East Anglia One North (EA1N) and East Anglia Two (EA2) Offshore Wind Farms

Planning Inspectorate Reference: EA1N – EN010077, EA2 – EN010078

Deadline 4 – 13 January 2021

Comments of Suffolk County Council as Local Highways Authority

DRAWING No. TP-PB4842-DR003 REVISION D0.4

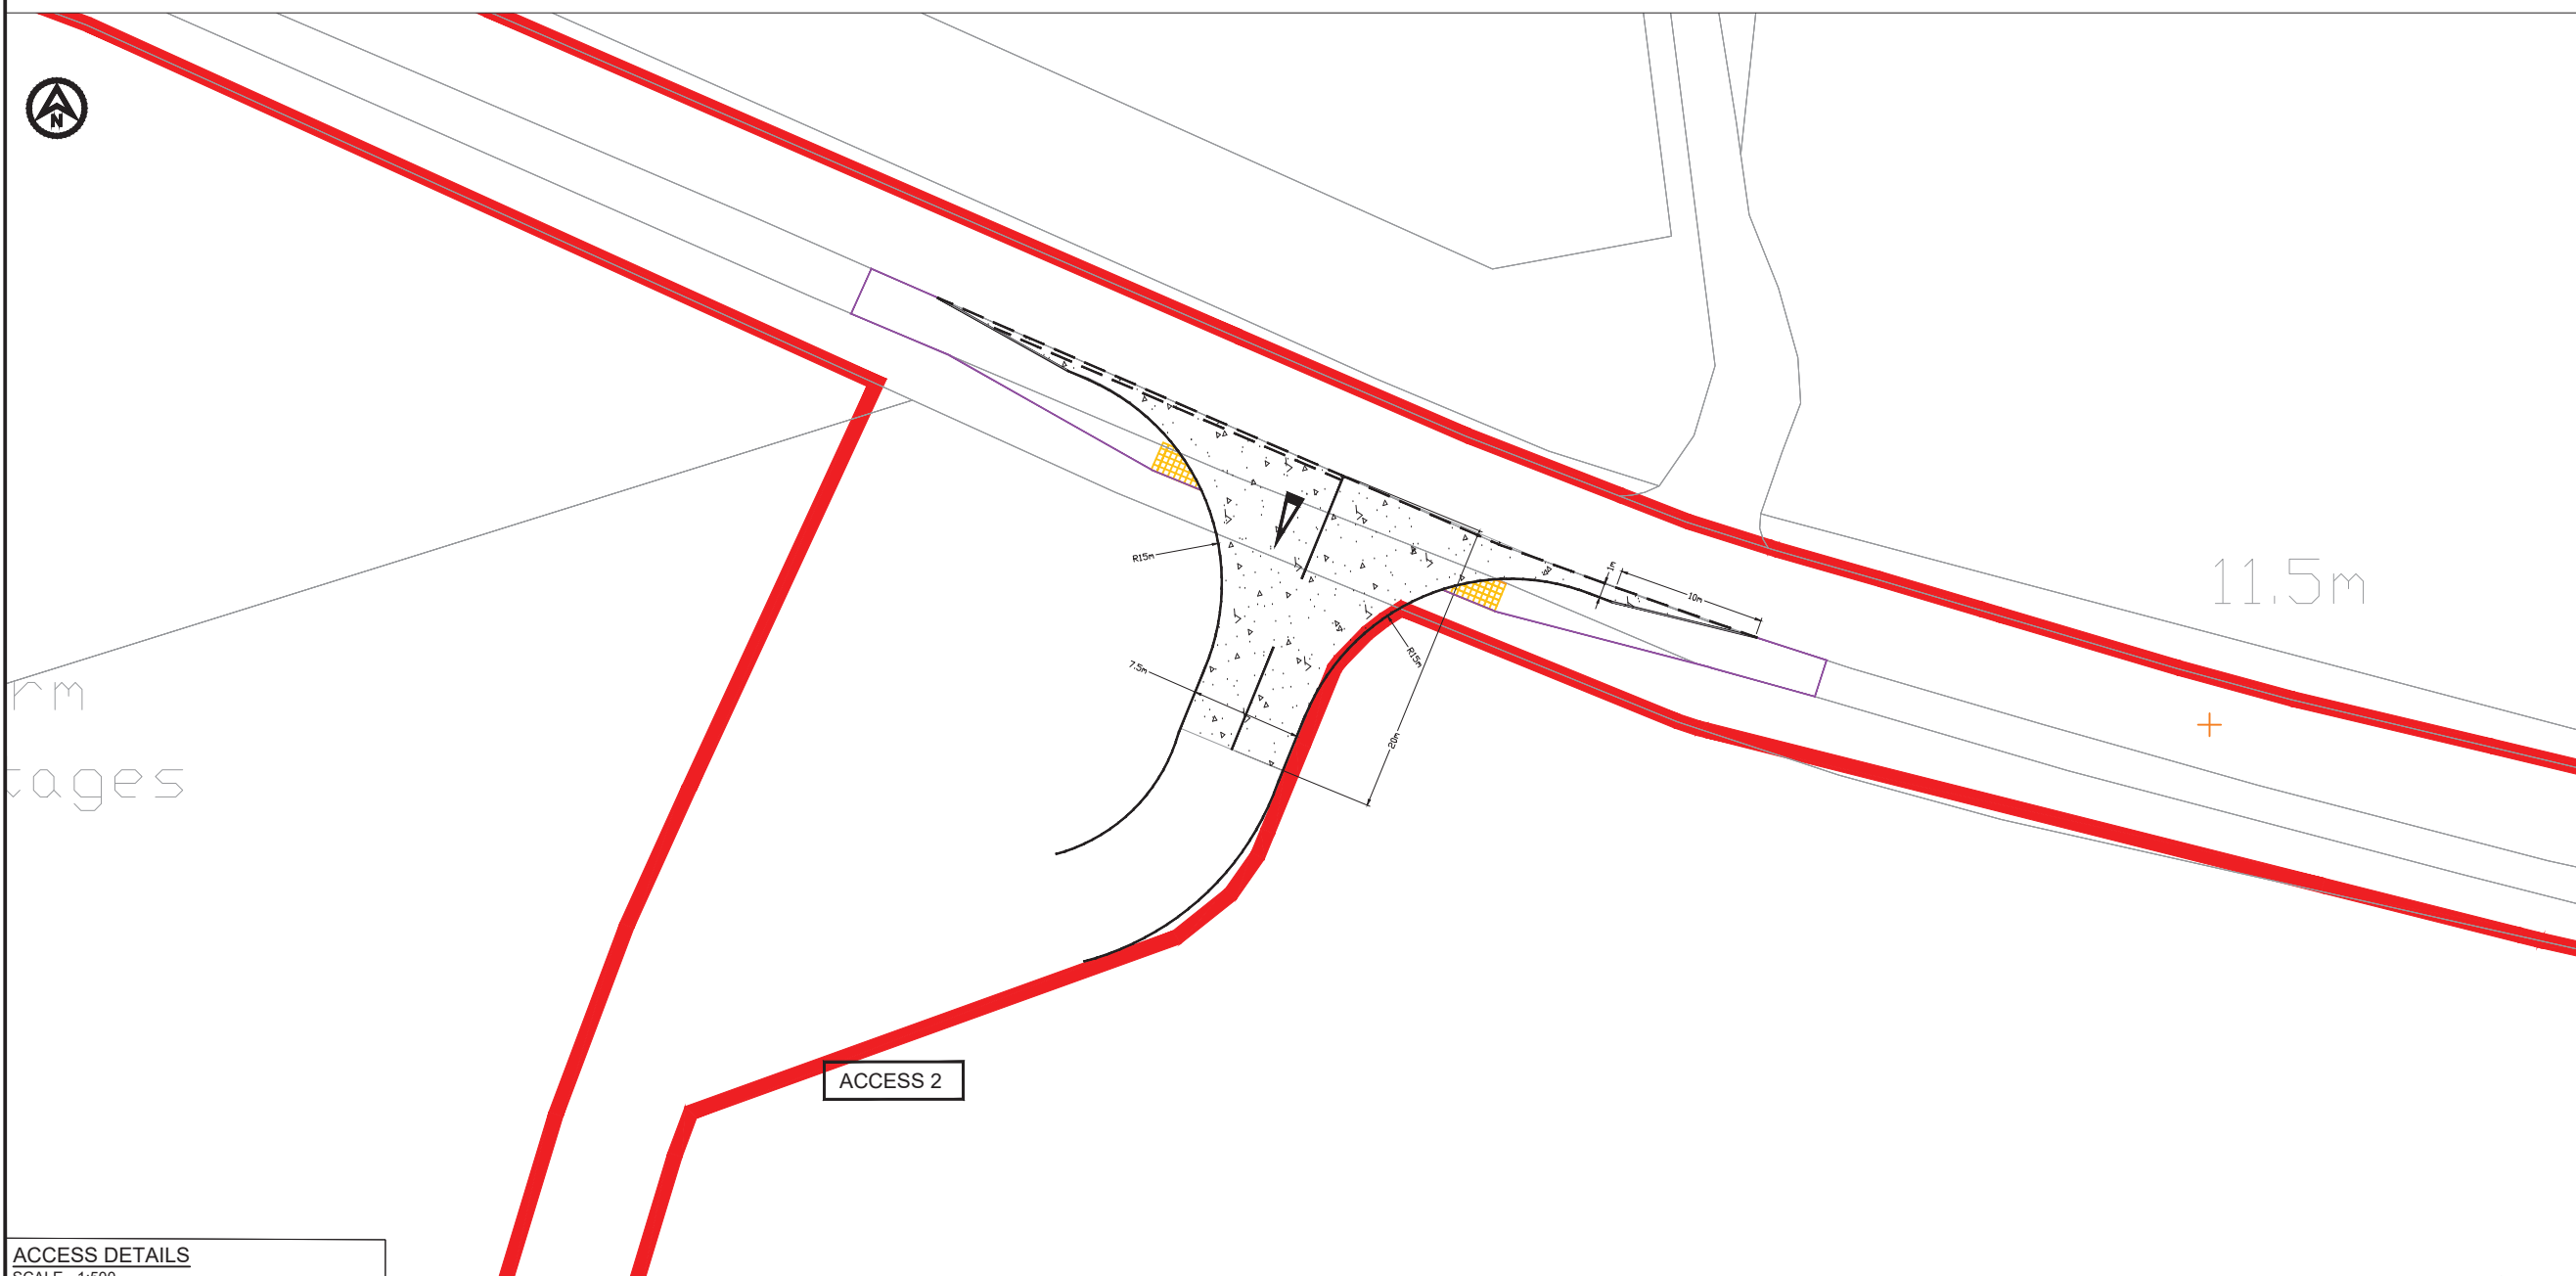
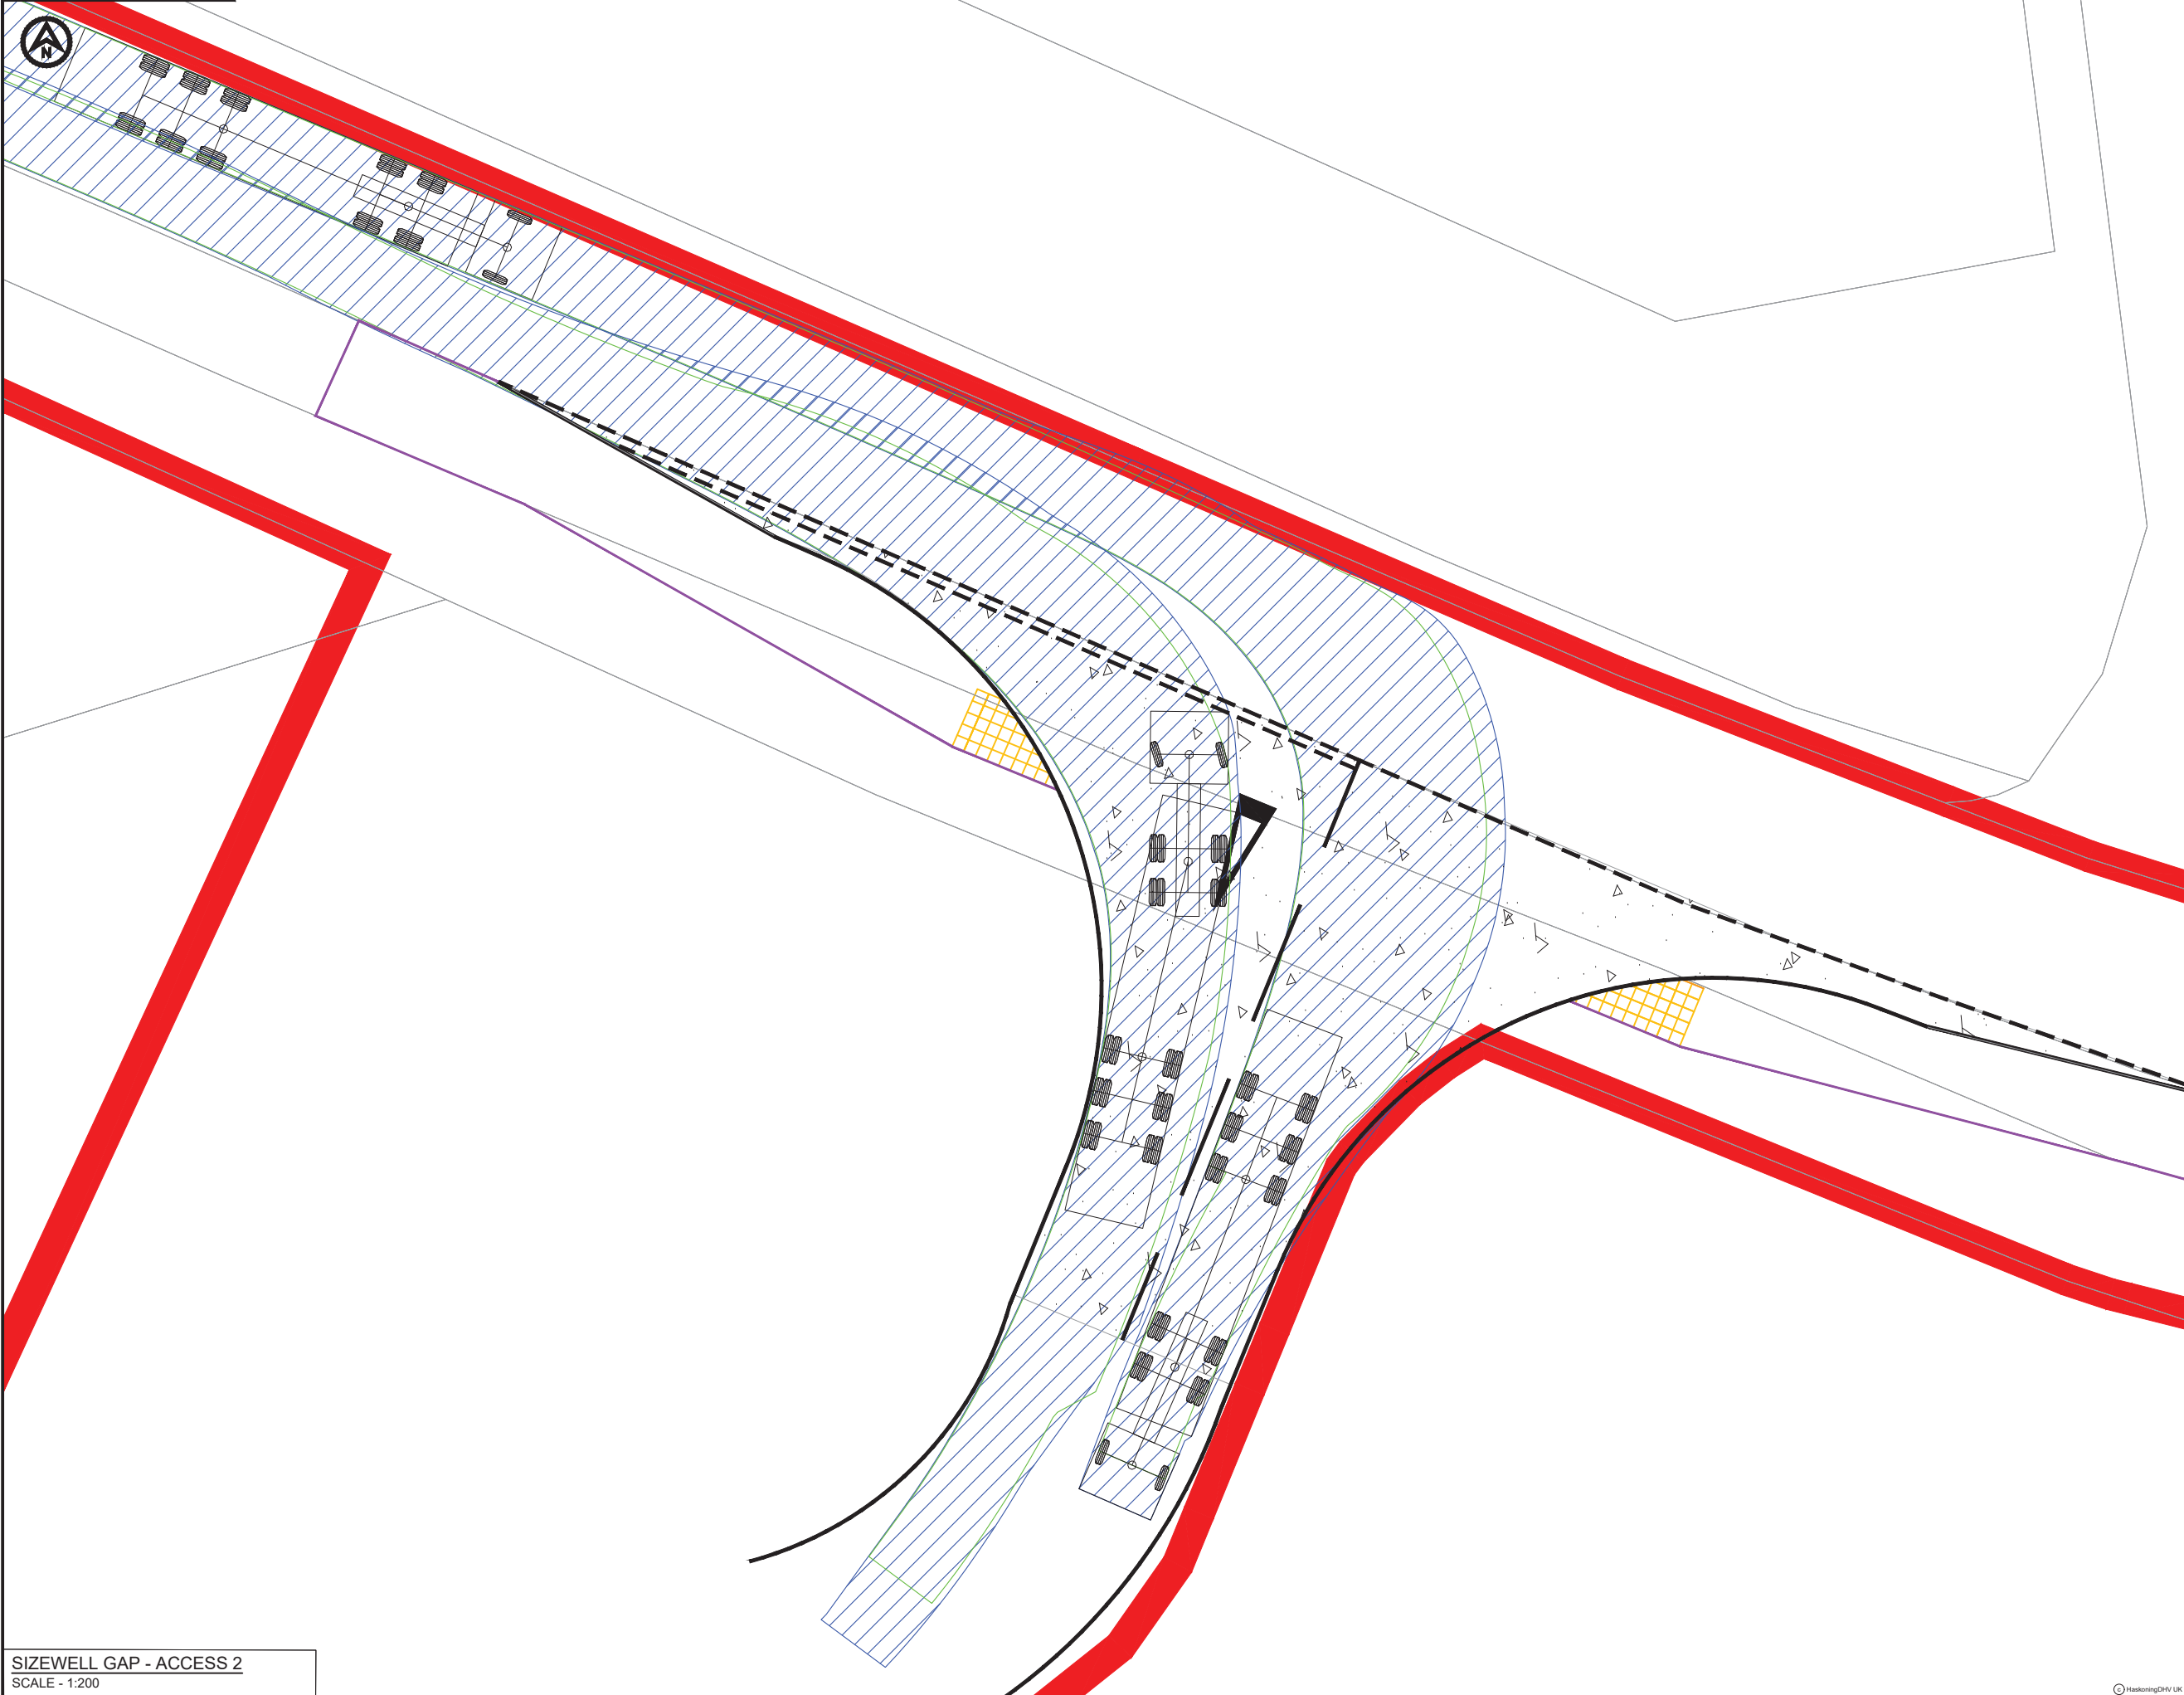
3.11 Drawing TP-PB4842-DR003 for access 2 shows the edge of the carriageway tight against the red line boundary. The LHA would suggest the applicant satisfies themselves that enough room has been allowed for construction of the carriageway.

DRAWING No:
TP-PB4842-DR011

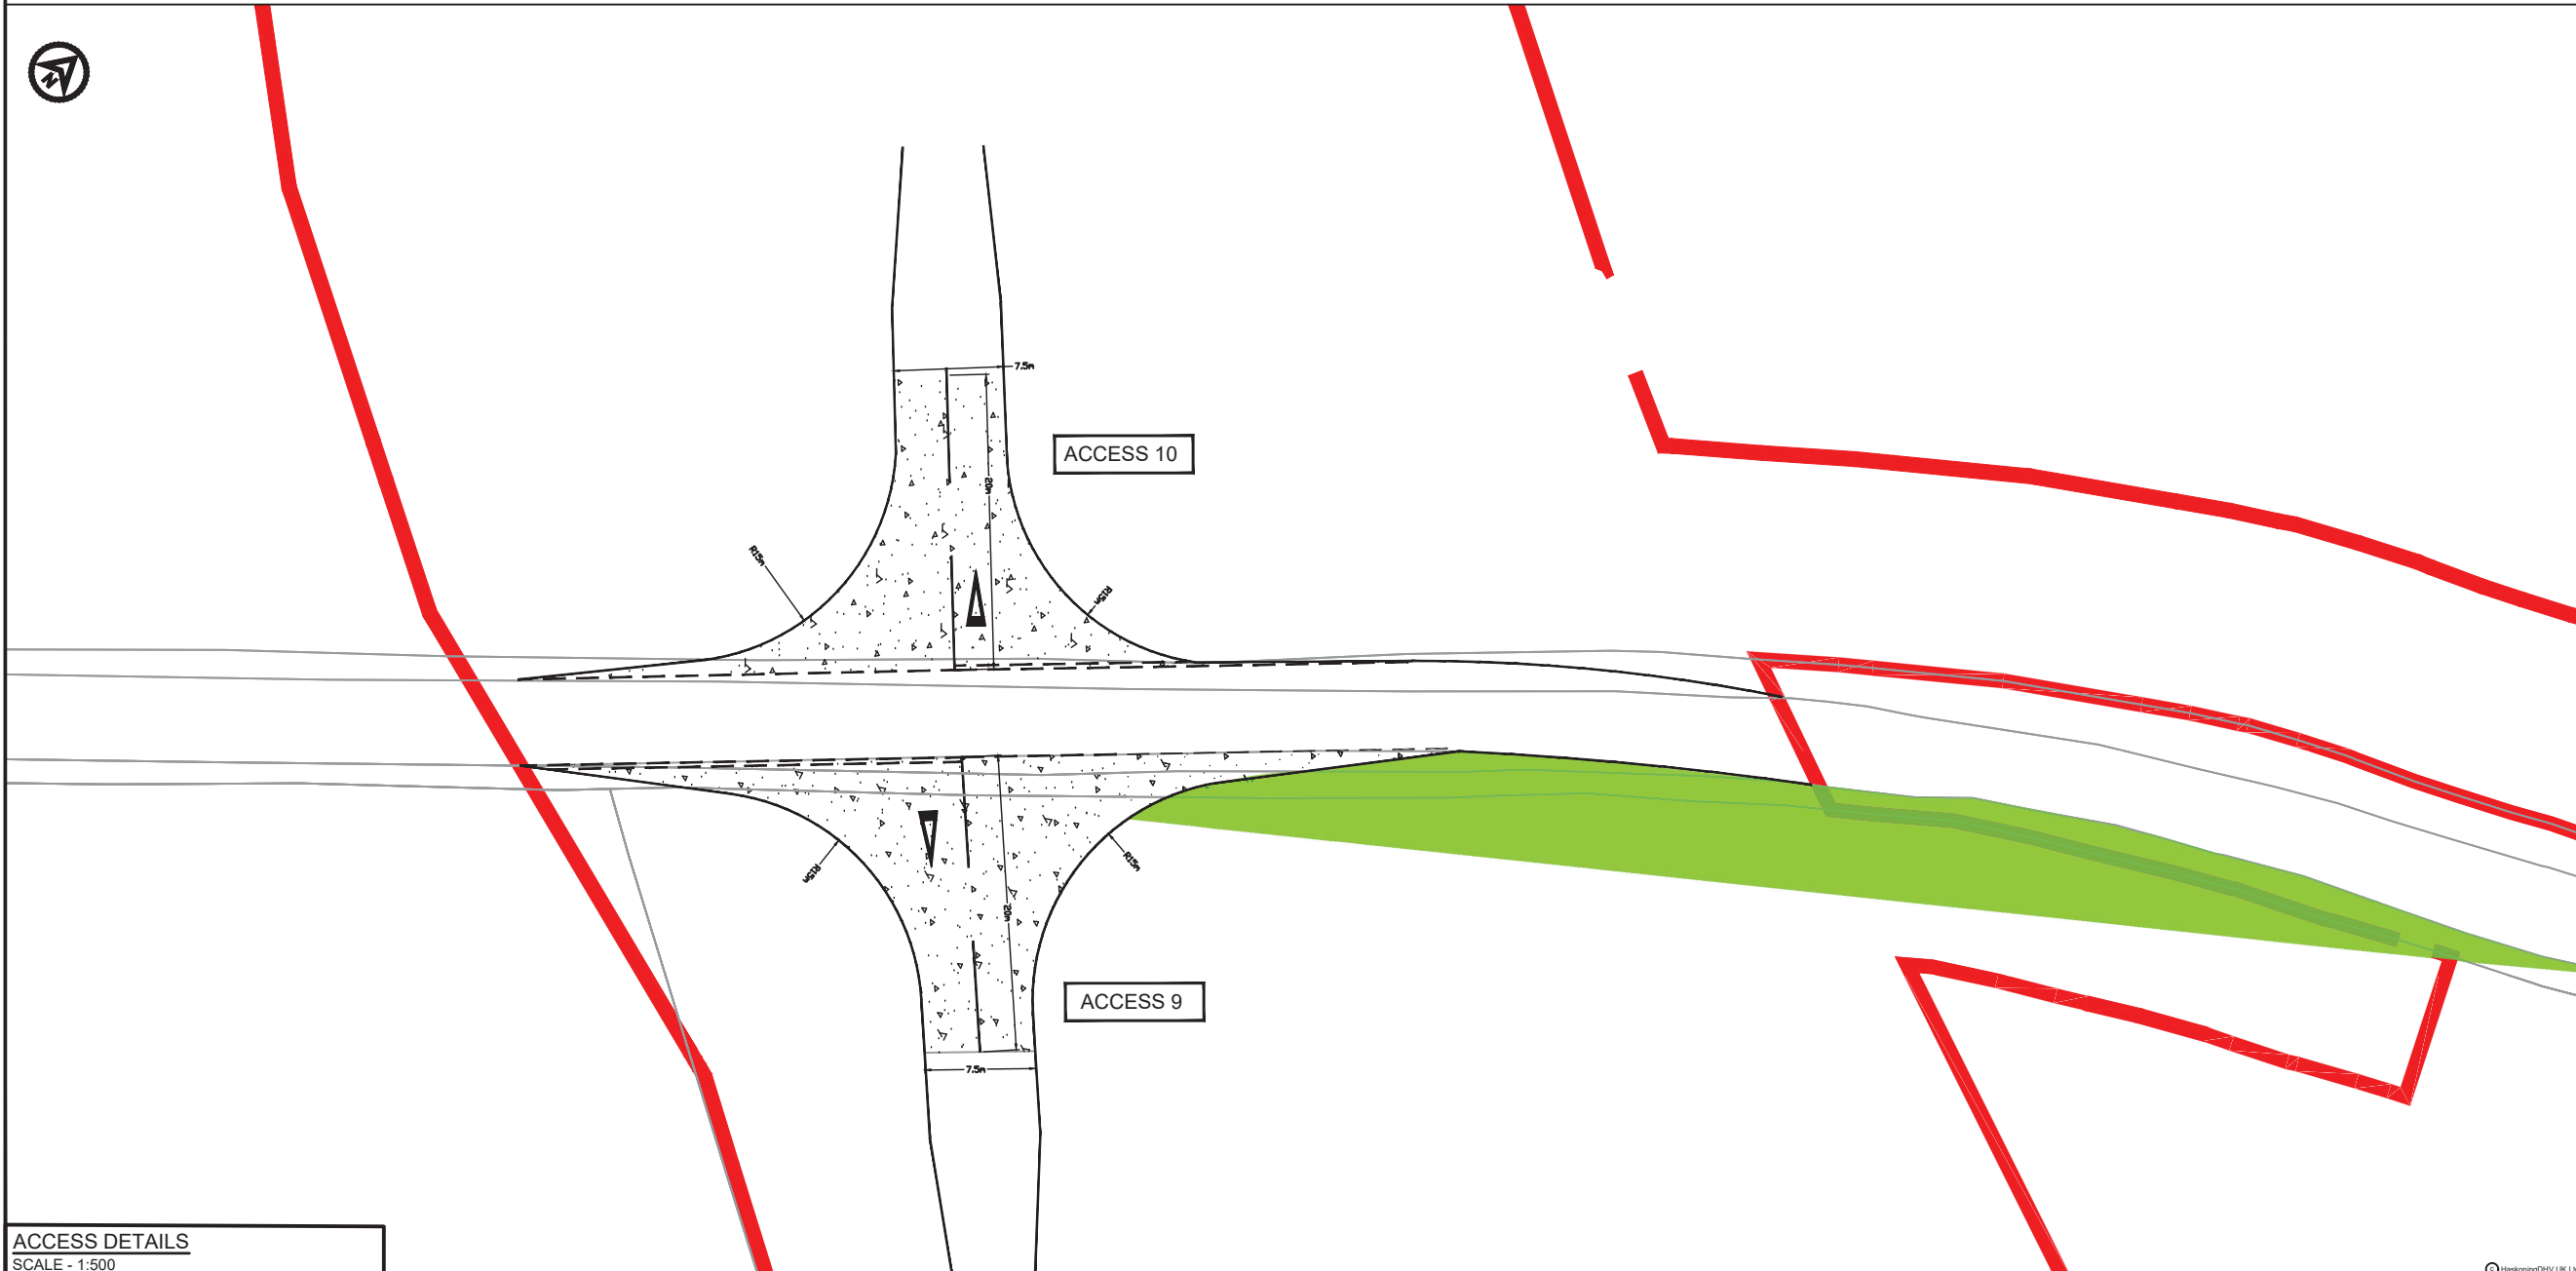
3.12 Drawing TP-PB4842-DR011 shows a small area east of access 9 where the visibility splay is outside the red line and also the highway boundary. The applicant will need to demonstrate that the visibility can be achieved and maintained for the duration of the project(s) so that safe access to the site can be achieved.
